Your Ref: OWPC14546
Our Ref: BR/153/17/RES 22-05-2017
Please ask for:
Mr S Davis

Application for approval of reserved matters following outline approval BR/84/16/OUT relating to appearance & landscaping
3 Southdown Road Bognor Regis

FRONT NORTH ELEVATION SCALE 1:100

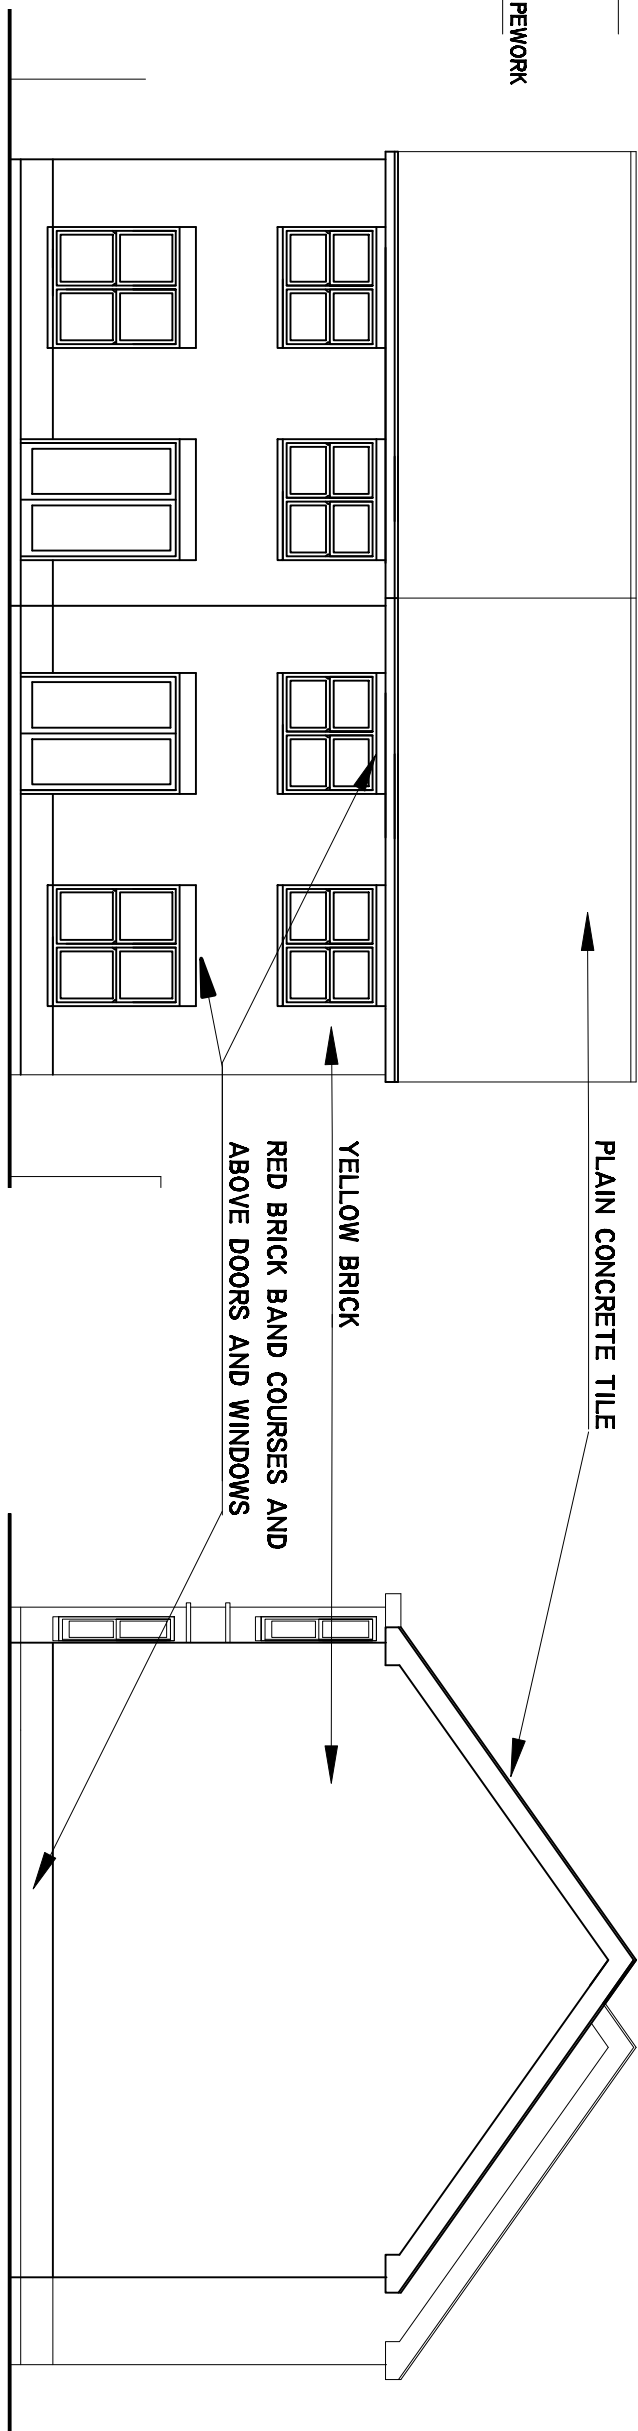
The original submission showed bay windows to the ground floor but flat or flush windows to the first floor. This application shows bay windows to both floors on the front elevation

This would result in a total loss of privacy in our back garden. I do not see that the upper bay windows are necessary from an aesthetic perspective but they would represent an unjustifiable intrusion into our privacy and enjoyment.
